KIRKLEES METROPOLITAN COUNCIL INVESTMENT & REGENERATION SERVICE

DELEGATED DECISION TO DETERMINE PLANNING APPLICATIONS

Reference No:	2023/62/93246/W
Site Address:	22, Burniston Drive, Oakes, Huddersfield, HD3 3PR
Description:	Erection of single and two storey extensions
Recommending Officer:	Joanna Rednall

DECISION – Conditional Full Permission

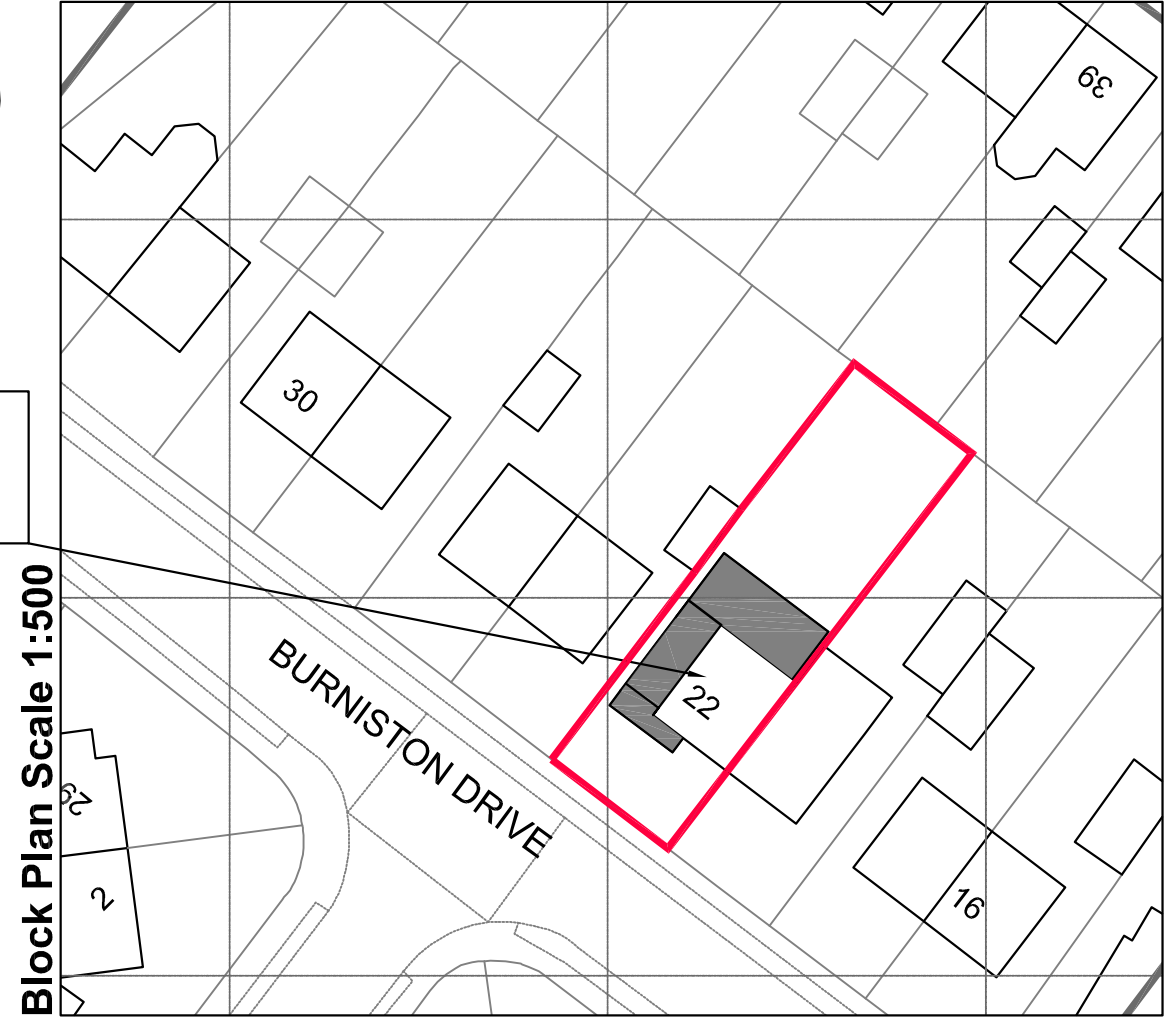
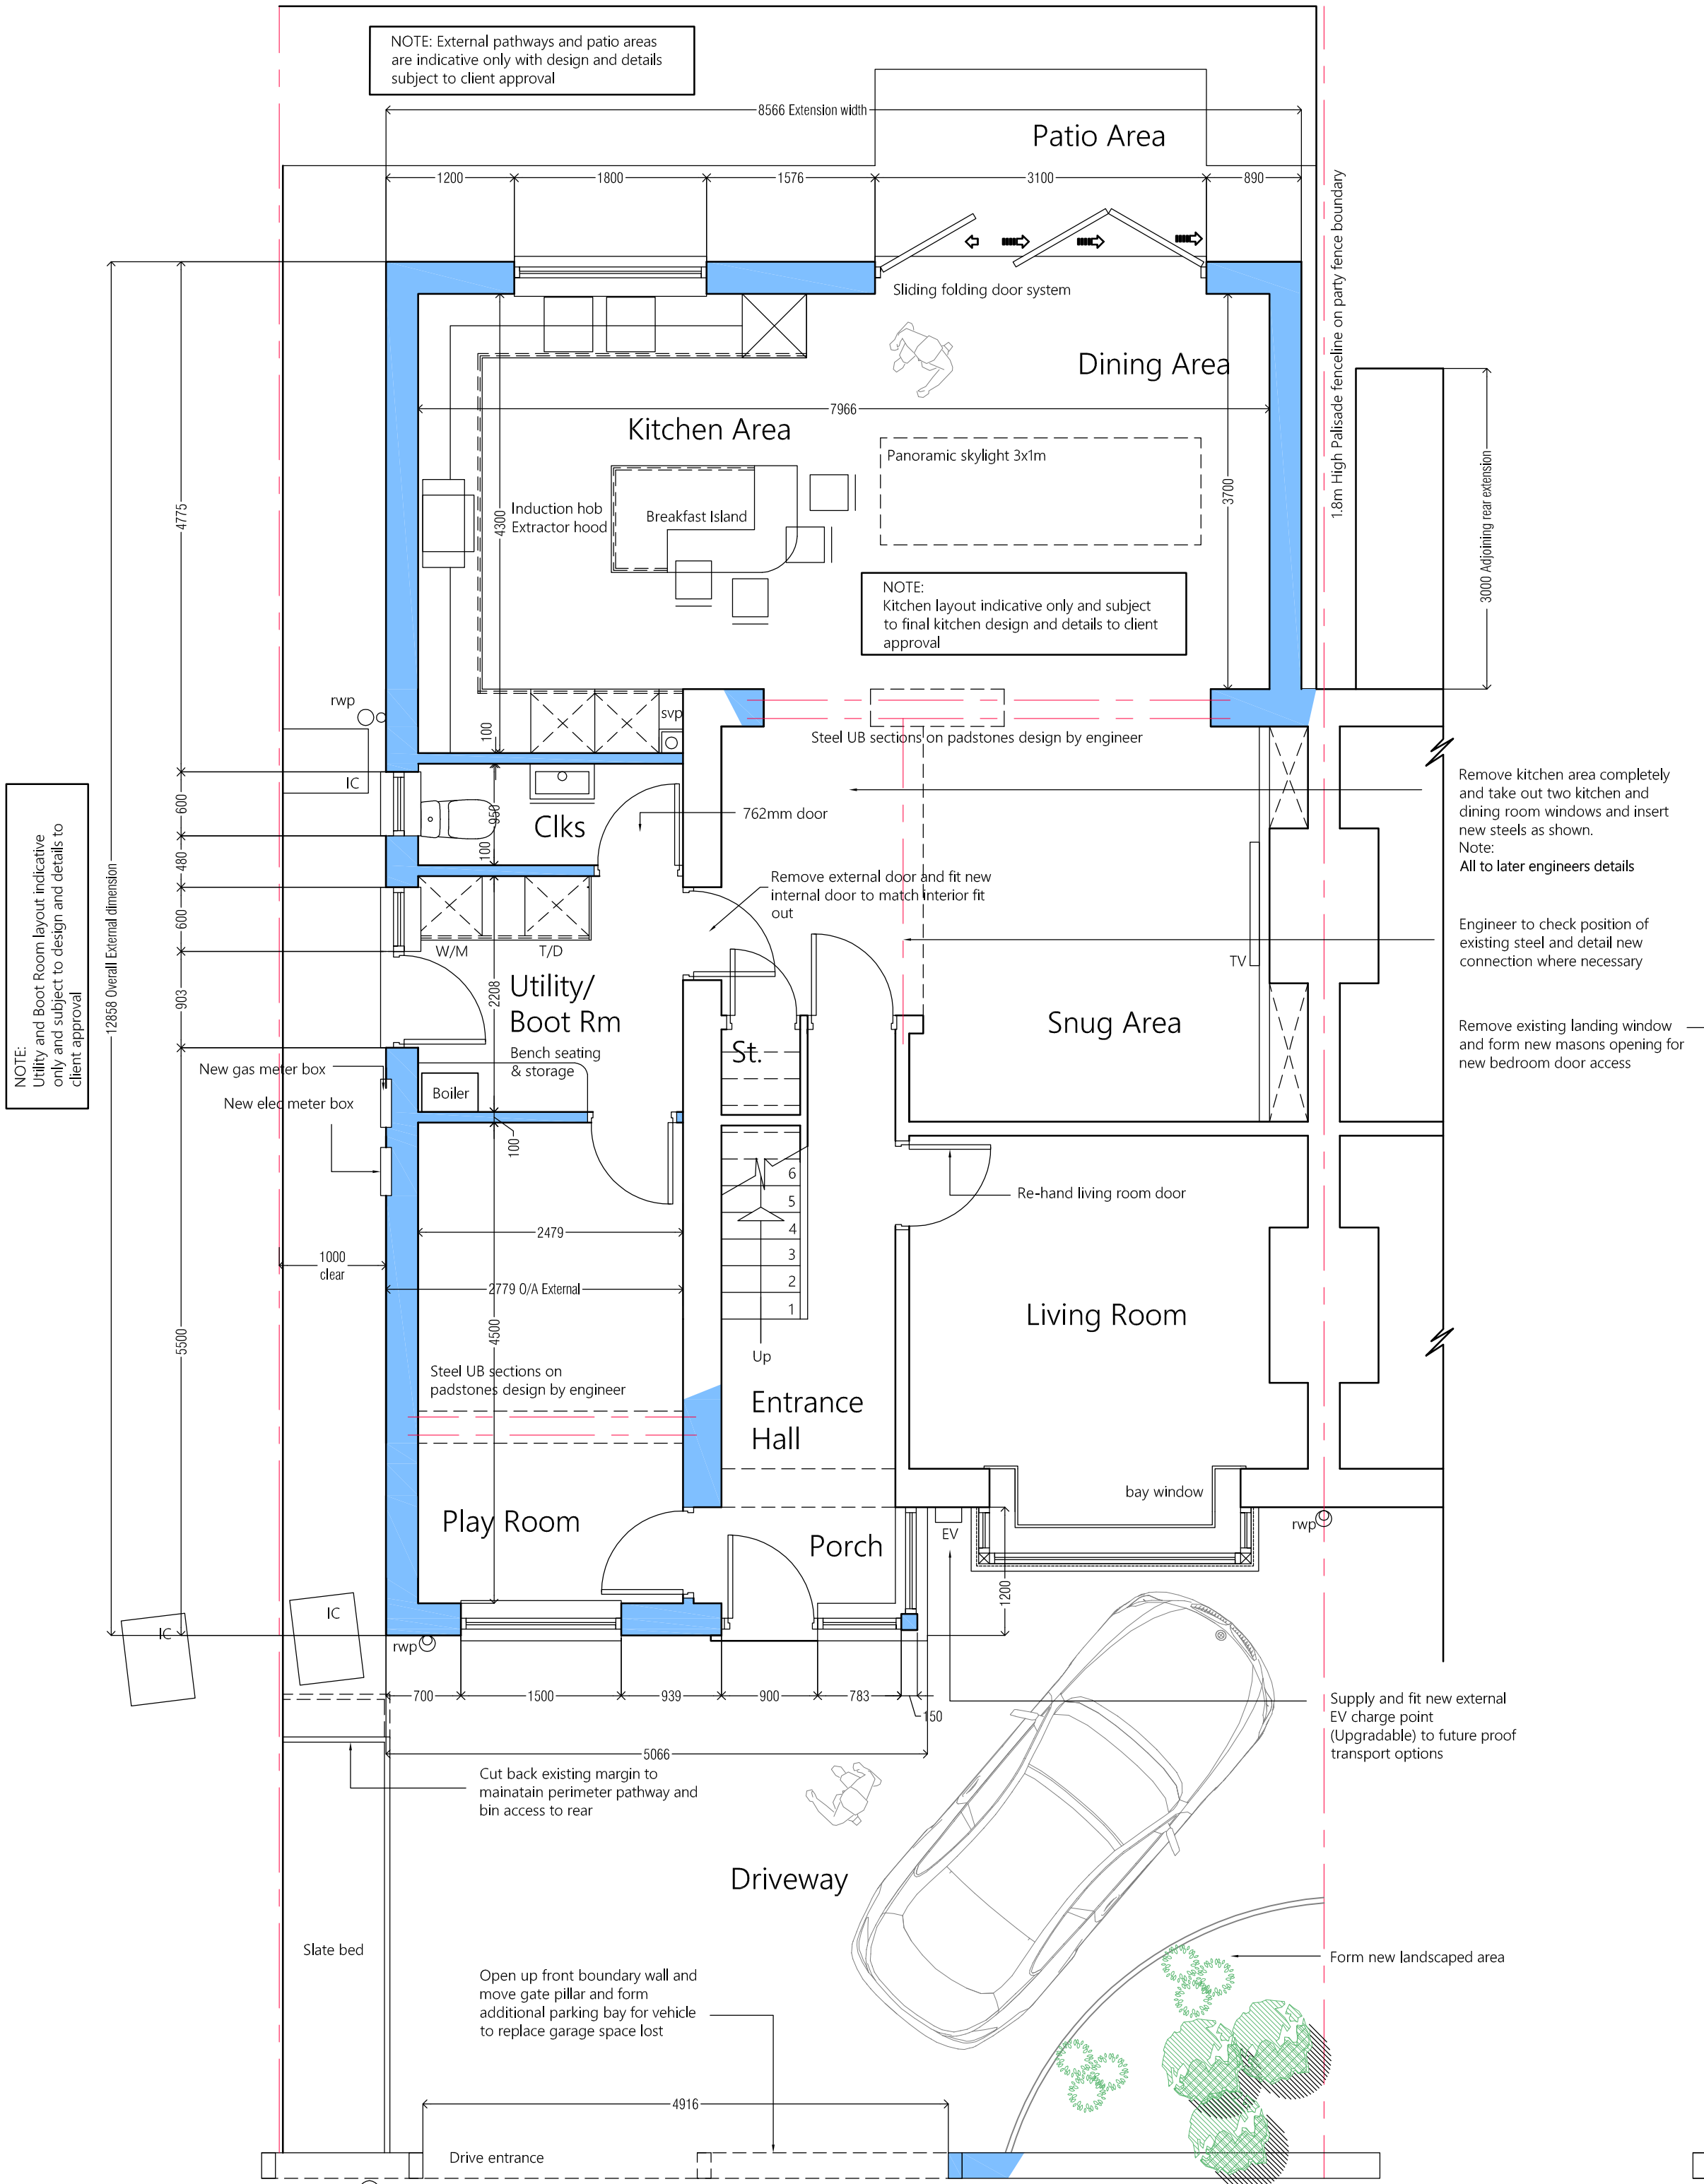
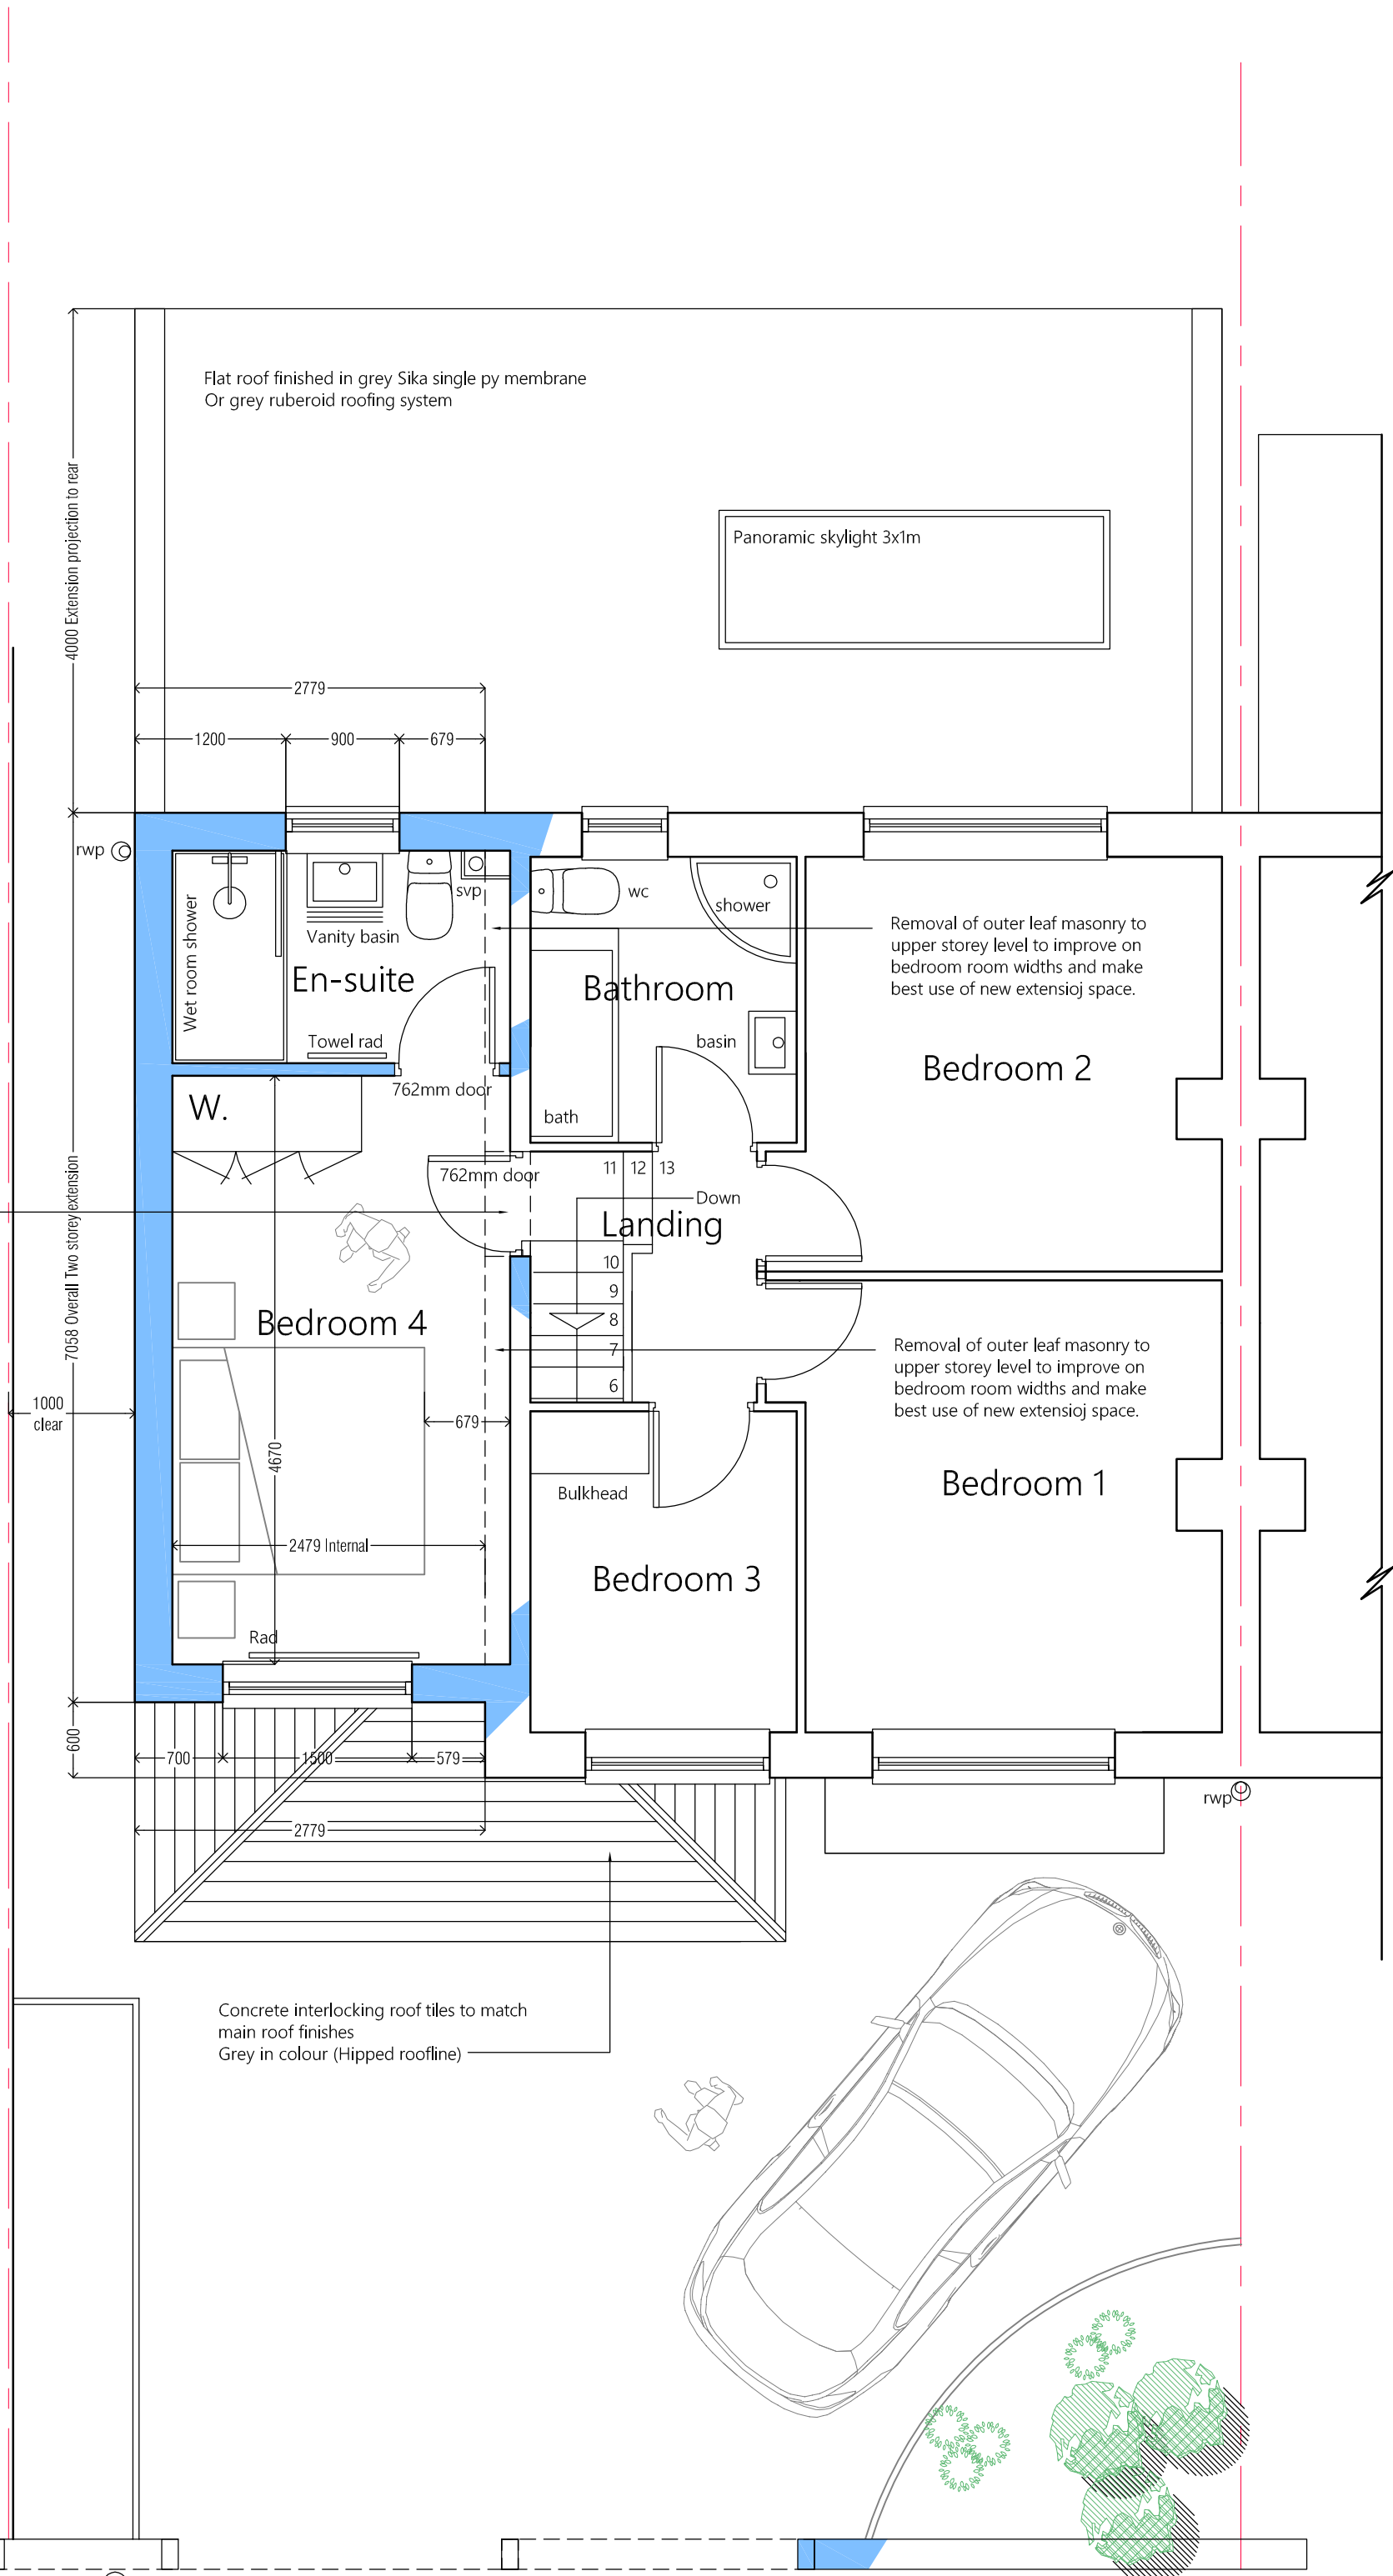
The agent was contacted regarding the rear and side projection and roof design. Amended plans were received with a hipped roof on the front extension and the side projection was decreased to maintain a 1 metre gap between the extension and boundary line.

The proposed two storey side extension would have two windows and a door on the north-west facing elevation. These are considered acceptable in this case as there is an existing window on the north-west elevation, and neighbouring property No.24 has a similar design of a door and window facing the application property. The extension maintains a 1 metre gap to the side boundary of this neighbour and maintains external access to the rear garden which is acceptable. In addition, the roof design would be hipped to follow the form of the existing roof, and ridgeline would be ~0.2 metres below the existing roof to allow for a visual break. The side extension is set back 600mm from the front face of the building.

In terms of the rear single storey extension, the projection would be ~4.3 metres which exceeds the SPD guidelines in paragraph 5.6. Given the size of the rear garden, there would be ~15 metres from the extension to the rear boundary therefore would not cover more than half of the total area around the original dwelling. In addition, although the extension would exceed 3 metres for semi-detached dwellings, the height of the eaves would not excessively exceed 2.5 metres. The rear extension would be single storey in height with a flat roof to mitigate the impact of scheme and it would be seen against an extension at no. 20.
